Yorkshire Water Services
Developer Services
Sewerage Technical Team
PO BOX 52
Bradford
BD3 7AY

Your Ref: 2024/92504
Our Ref: A005360

21st November 2024

134 Birkby Hall Road, Birkby, Huddersfield – Change of use from vehicle repair and sales to vehicular repair, sales and hand car wash with associated works

Drawing Title:  
EXISTING AND PROPOSED PLAN.

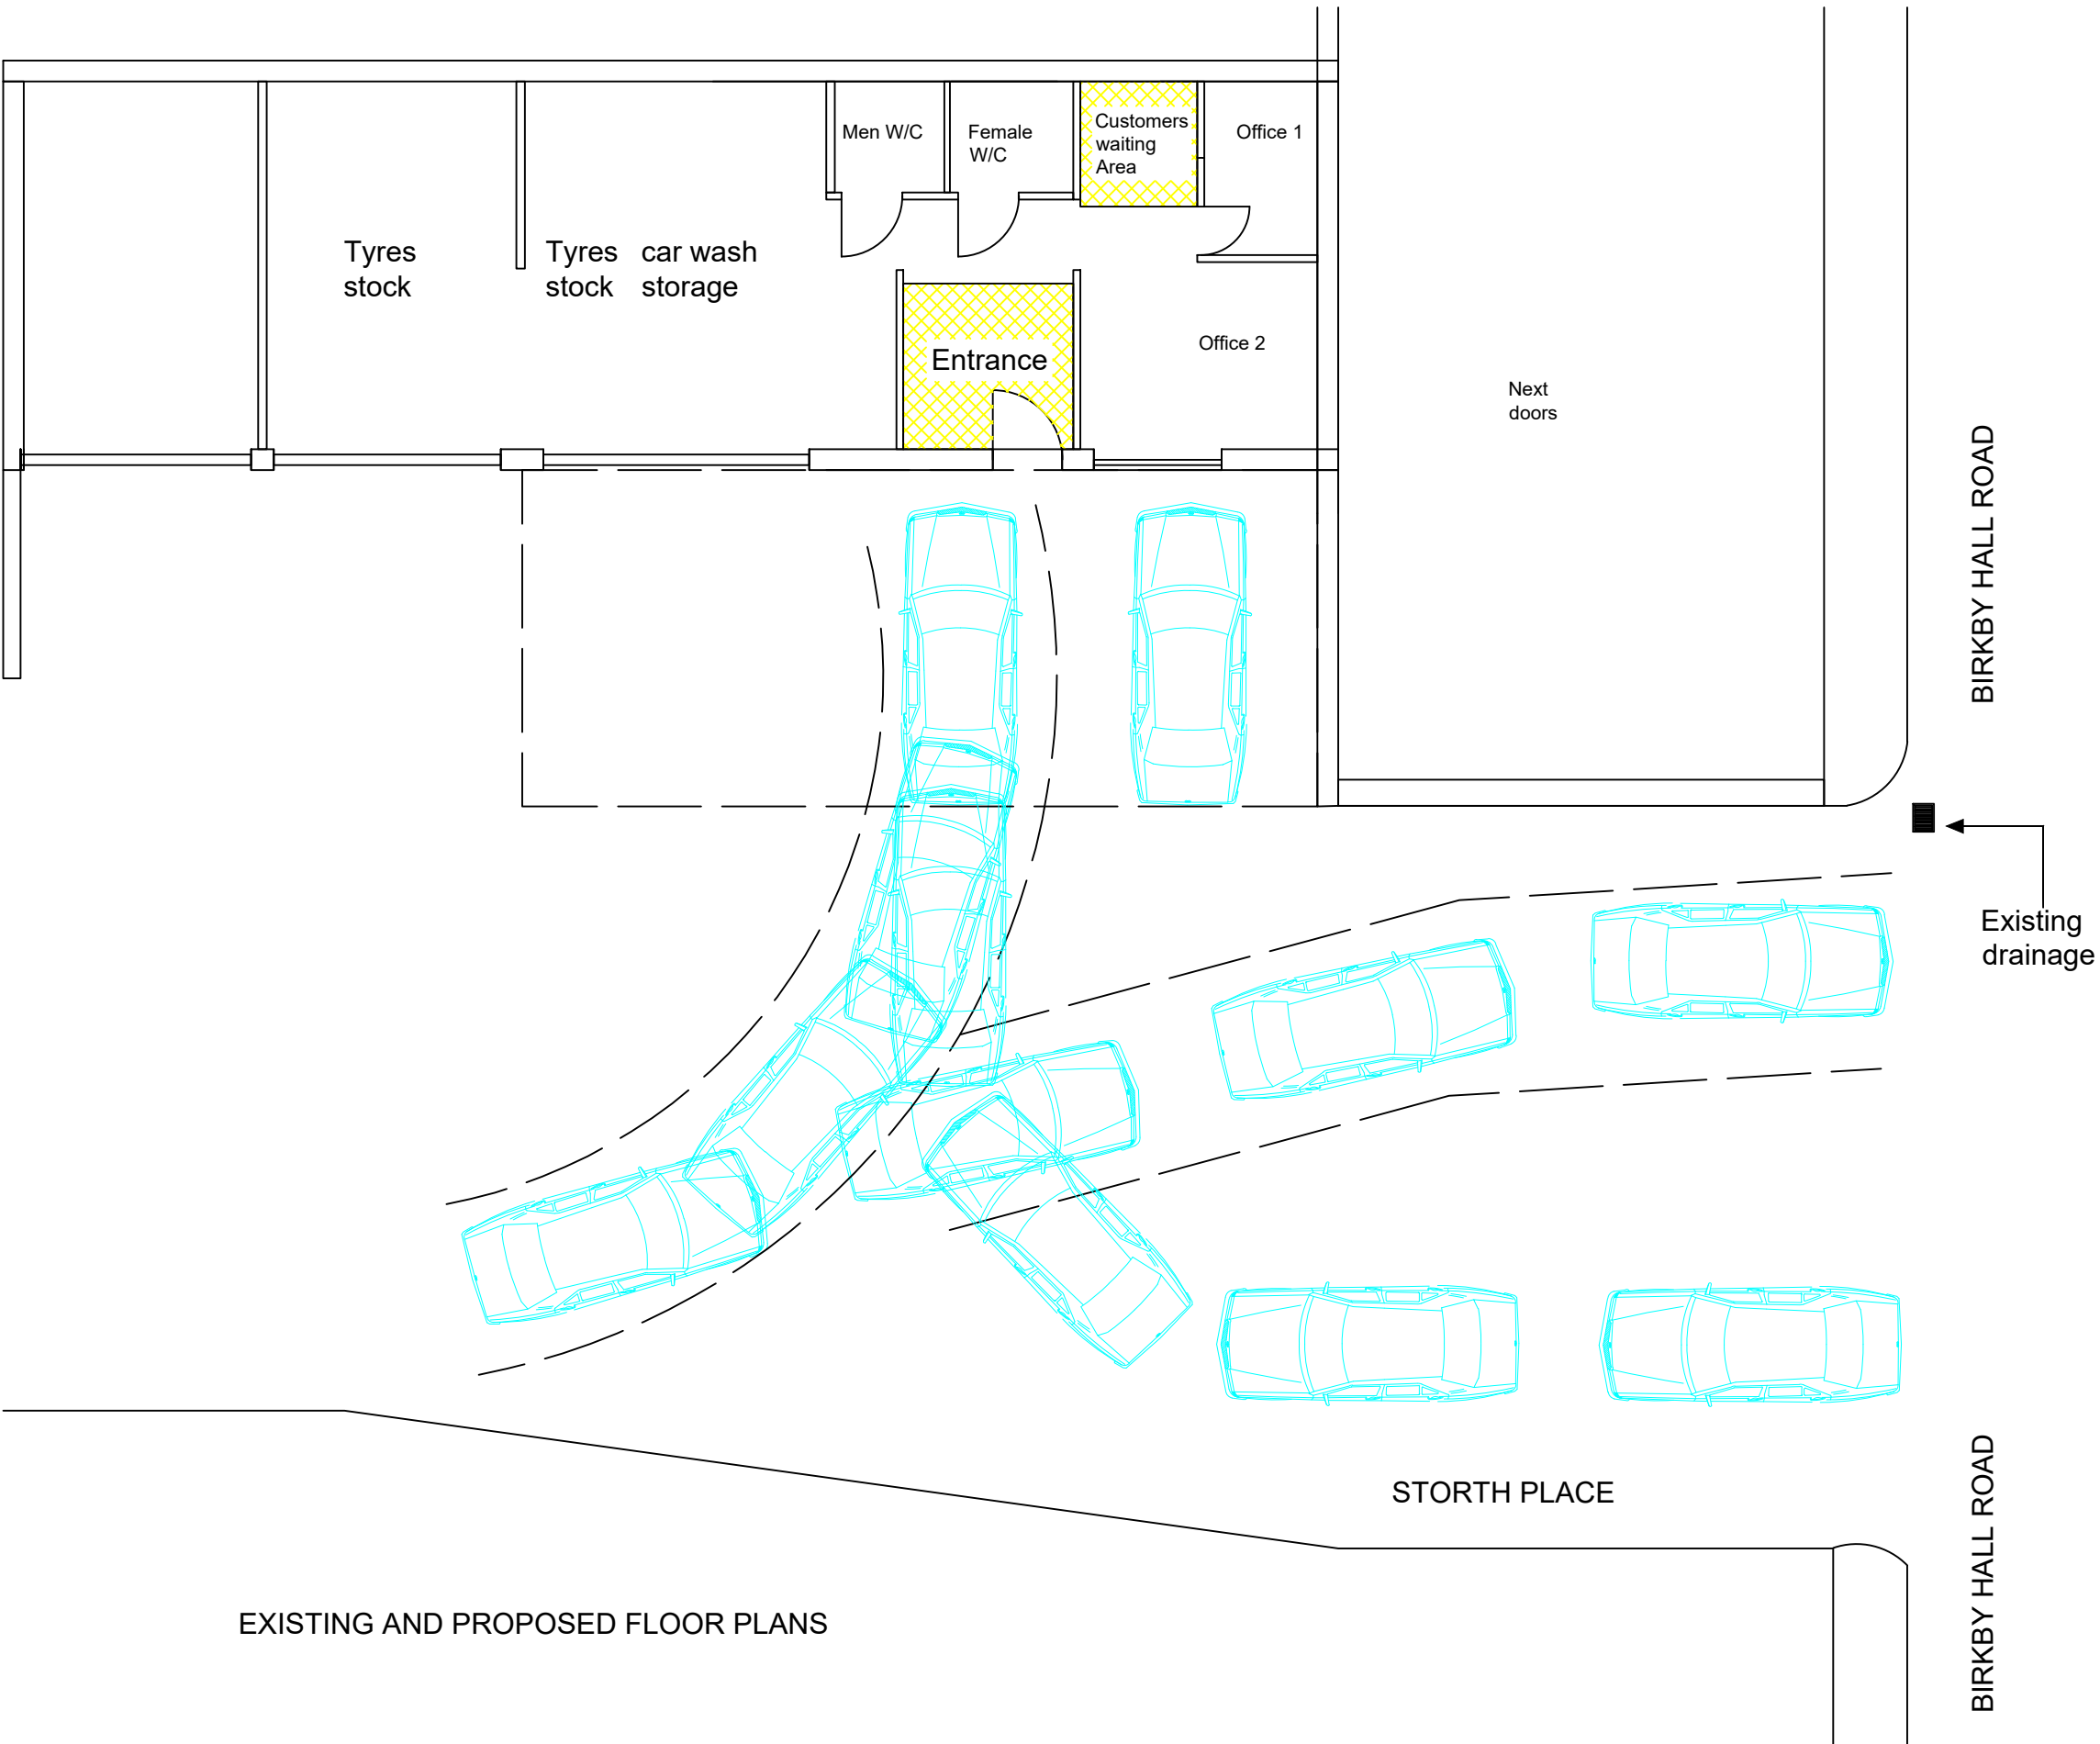
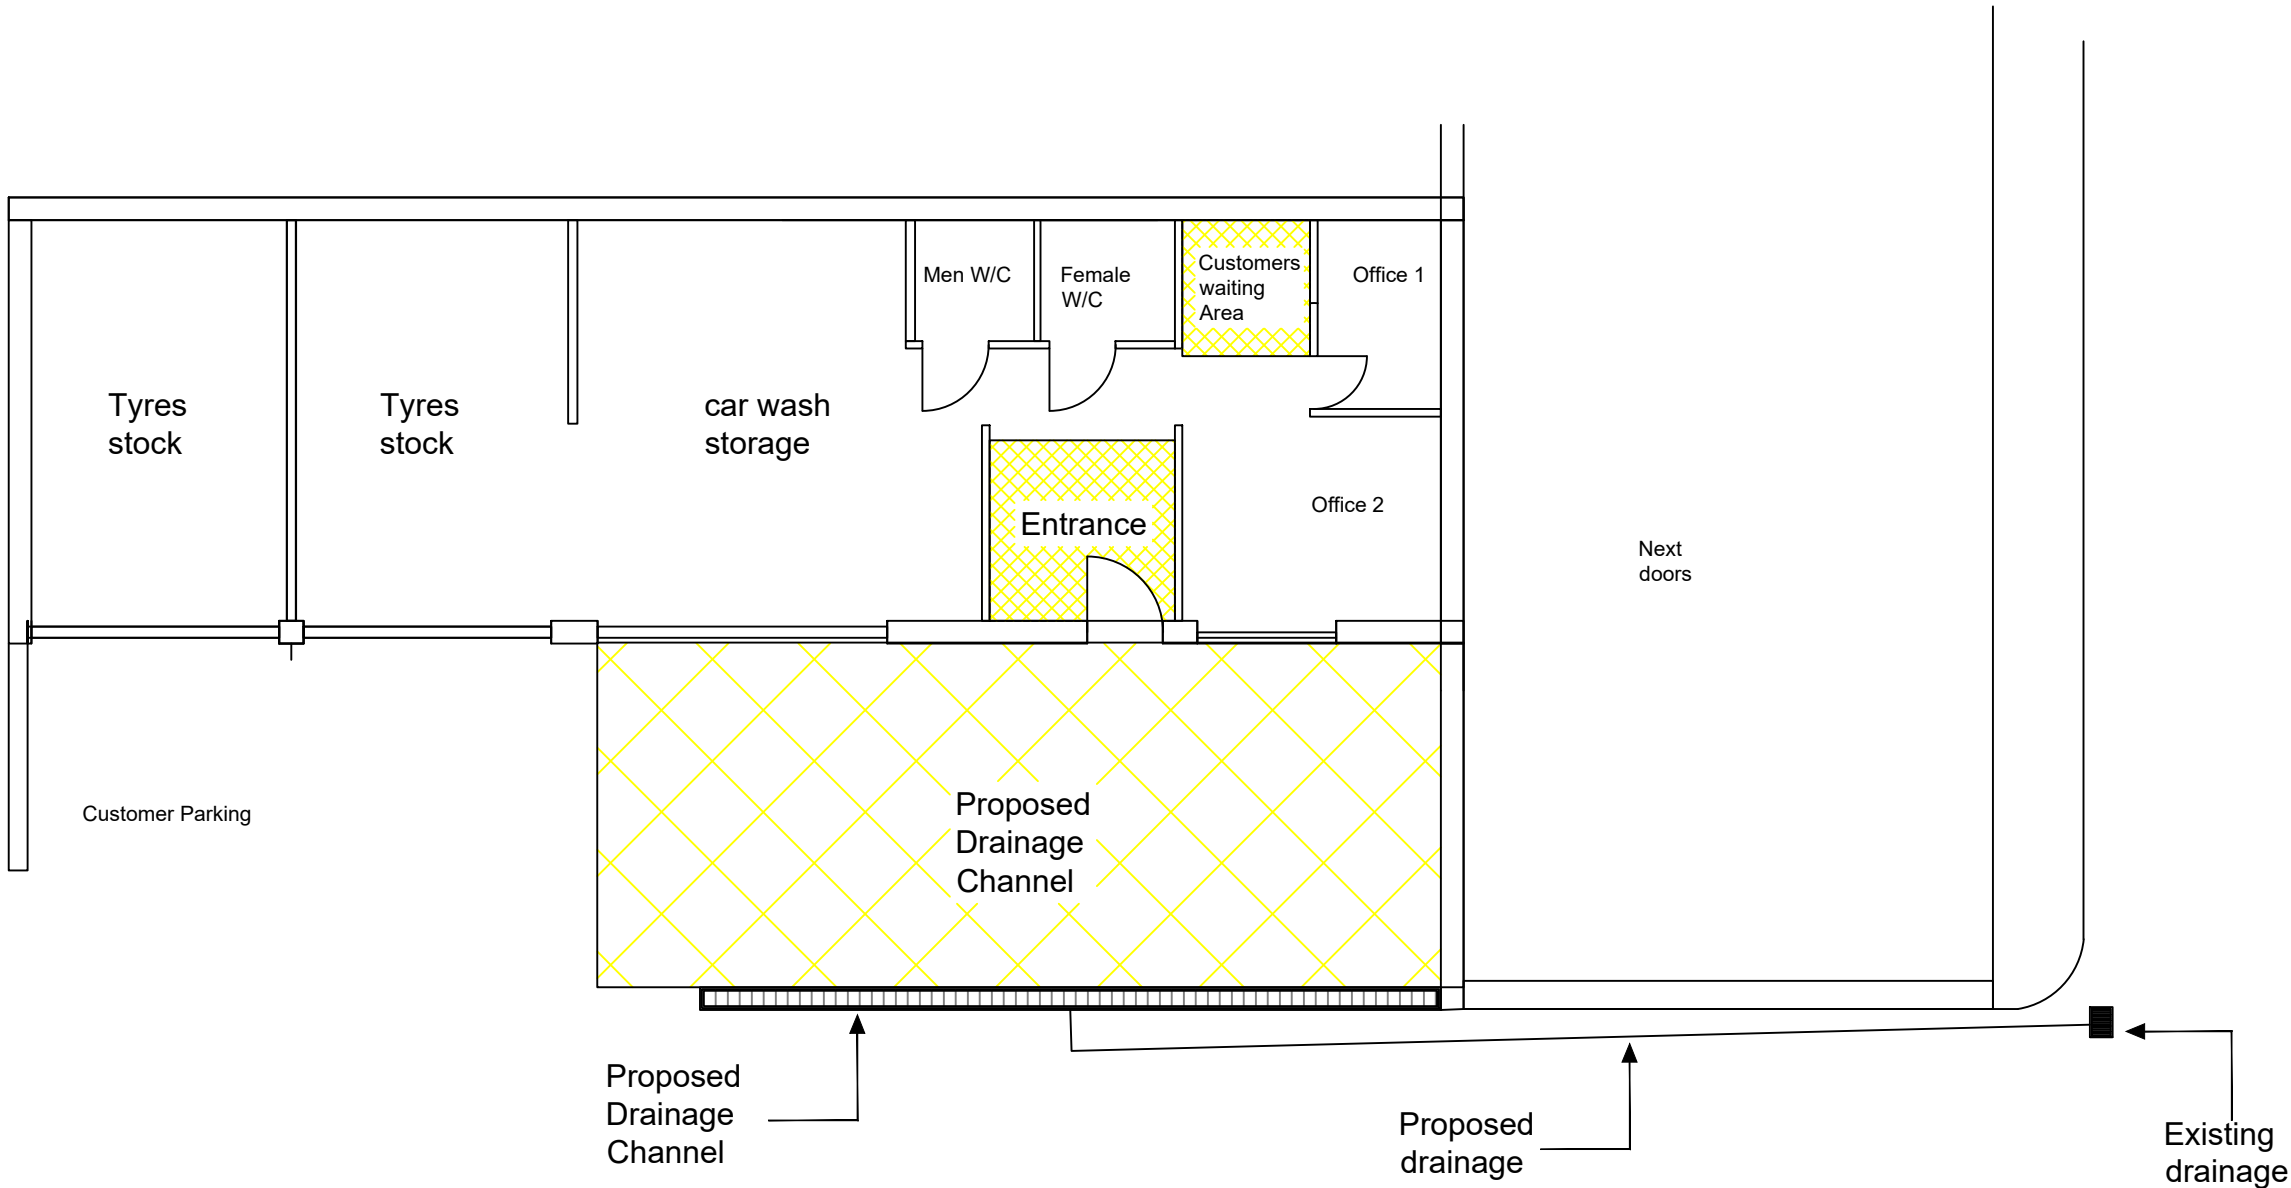
Surface water run-off from the forecourt of petrol stations, areas used for the delivery of fuel, areas used for and immediately adjacent to vehicle washing facilities and/or other similar areas where detergent is likely to be used shall not discharge to any public surface water sewer network. Surface water from such areas must pass through an oil, petrol and grit interceptor/separator of adequate design that has been submitted to and approved by the Local Planning Authority, before discharge to the public foul or combined sewer network.

1.) It is imperative that surface water run-off from the forecourt of petrol stations, areas used for the delivery of fuel, areas used for and immediately adjacent to vehicle washing facilities and/or other similar areas where detergent is likely to be used is not discharged to any public surface water sewer network.

a.) Surface water from such areas must pass through an oil, petrol and grit interceptor/separator of adequate design before discharge to the public foul or combined sewer network.

b.) It is good drainage practice for any interceptor/separator to be located upstream of any on-site balancing, storage or other means of flow attenuation that may be required.
